**WELWYN HATFIELD BOROUGH COUNCIL
ASSISTANT DIRECTOR (PLANNING)**

DELEGATED APPLICATION

Application No: 6/2022/2586/HOUSE
Location: 61 The Ridgeway Cuffley Potters Bar Hertfordshire EN6 4BD
Proposal: Erection of a single storey rear and front extension, increase in roof pitch, installation of two forward facing and one rear facing dormer, alterations to fenestration following demolition to existing rear and side extensions
Officer: Ms Kirsty Shirley

Recommendation: Granted

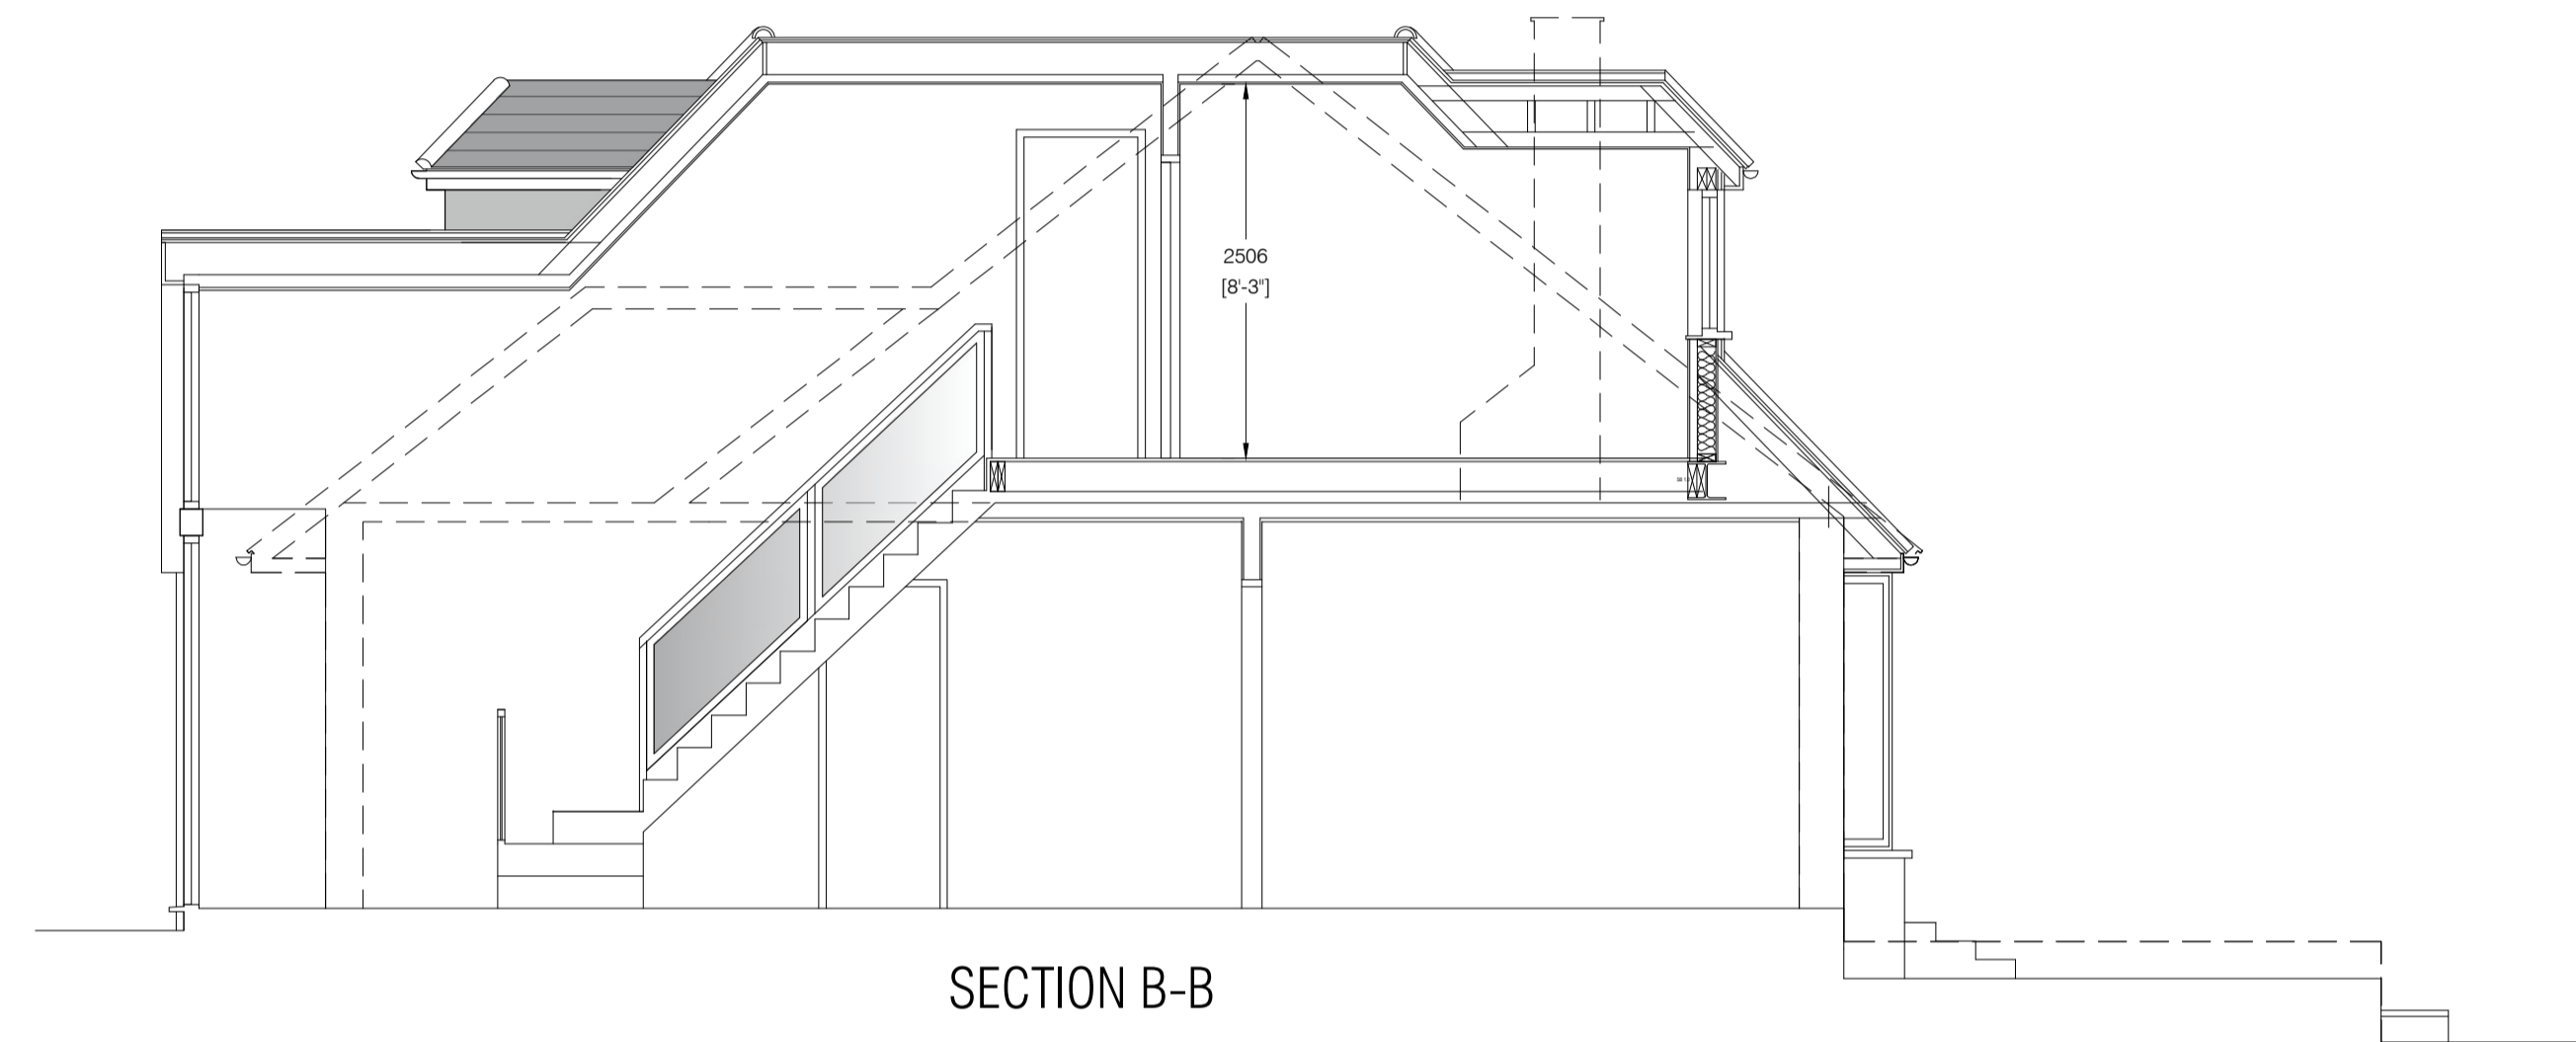
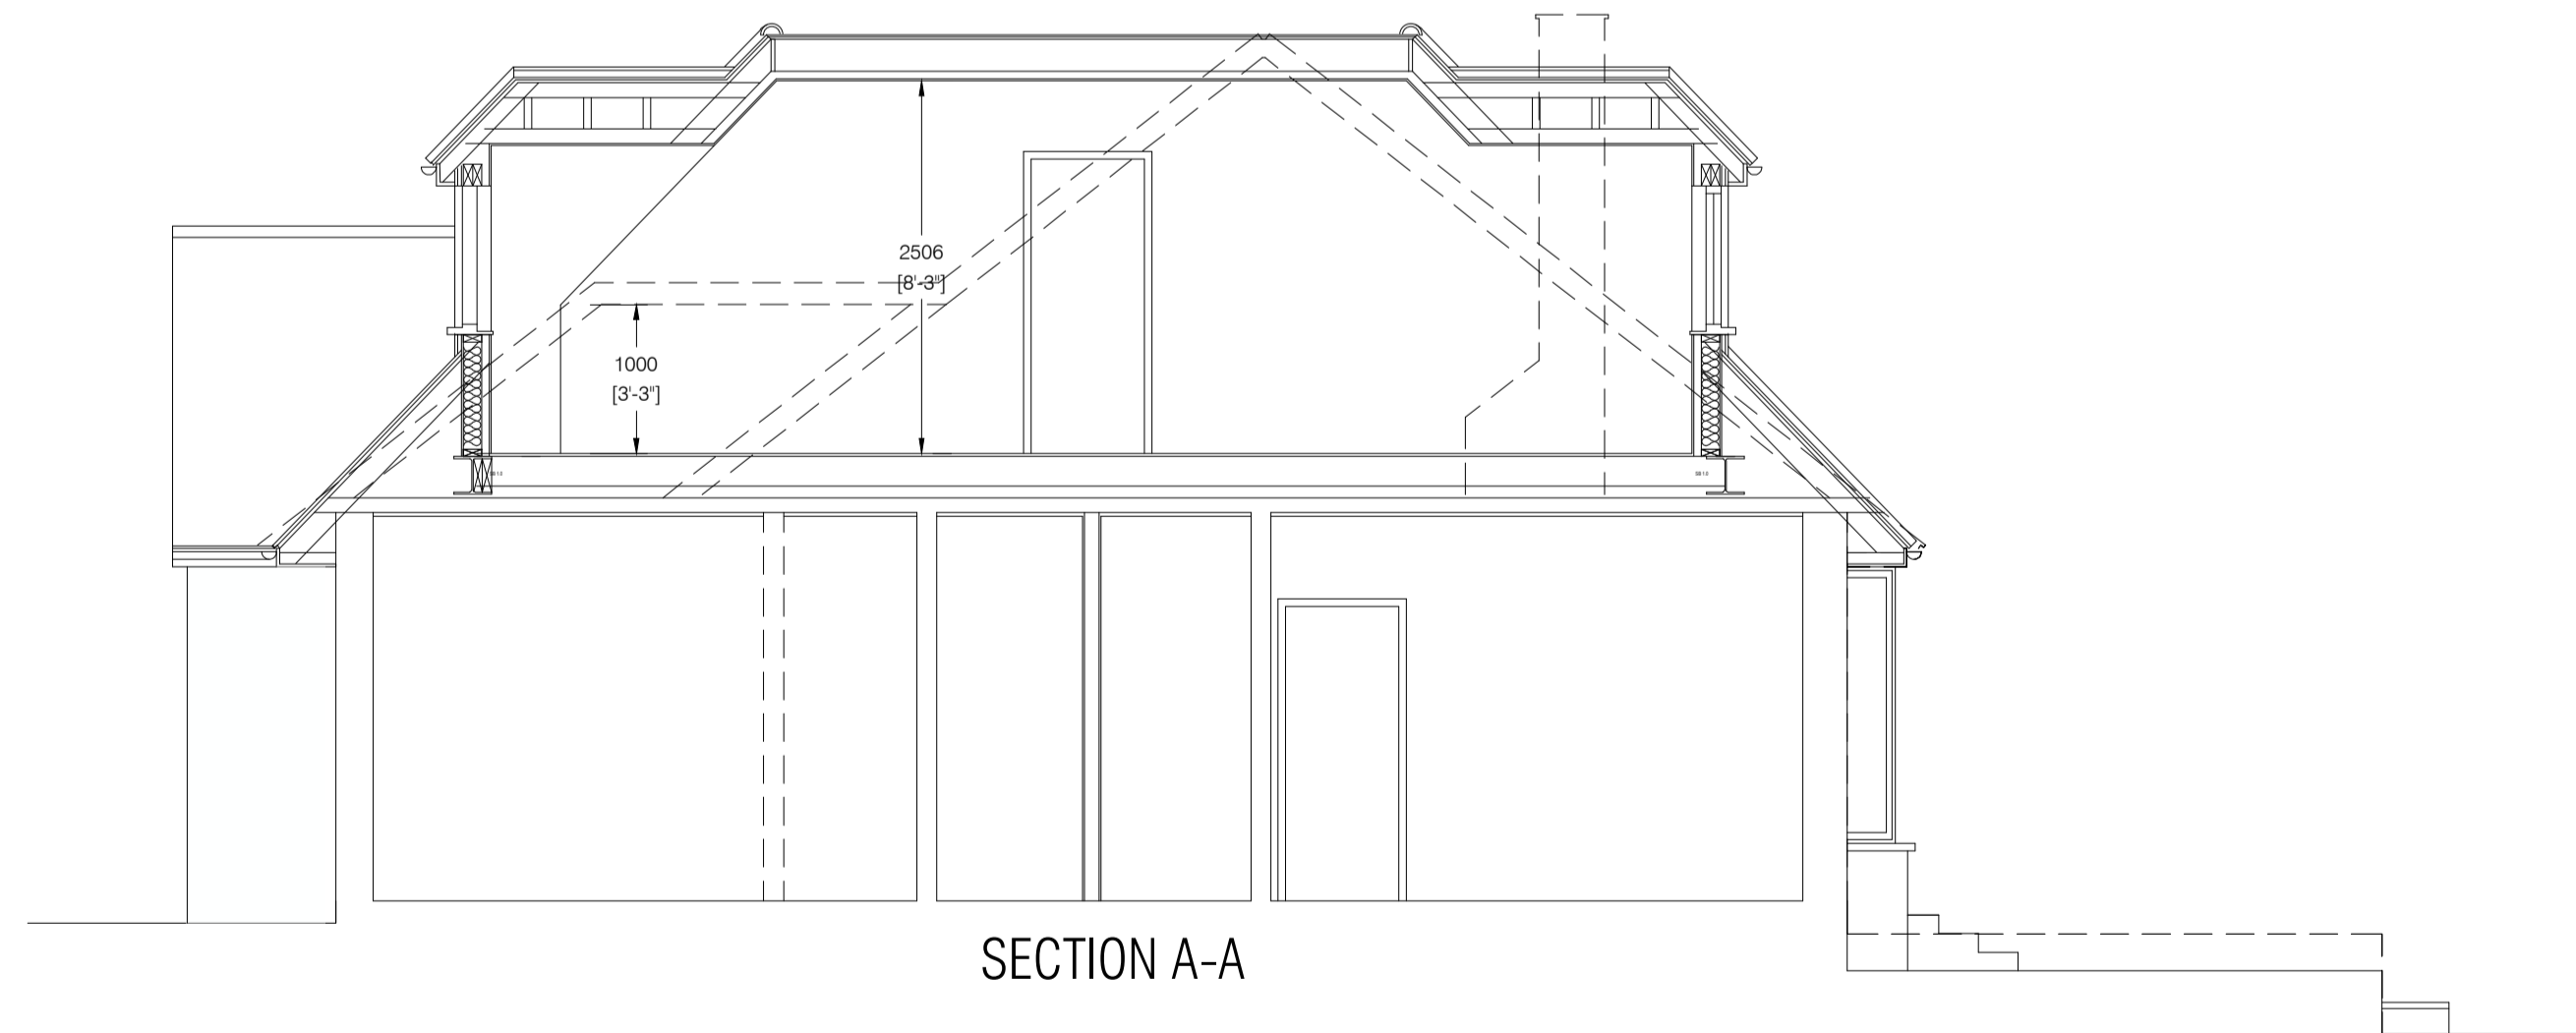
1. No development above ground level shall take place until details of the proposed crown roof, including a cross-section drawing, has been submitted to and approved in writing, by the Local Planning Authority. Subsequently the development must not be carried out other than in accordance with the approved details.

REASON: The proposal contains insufficient information in regards to the detailed design of the roof and this is required in the interests of quality of design and visual amenity in accordance with Policies GBSP2, D1 and D2 of the Welwyn Hatfield District Plan 2005 and the National Planning Policy Framework.
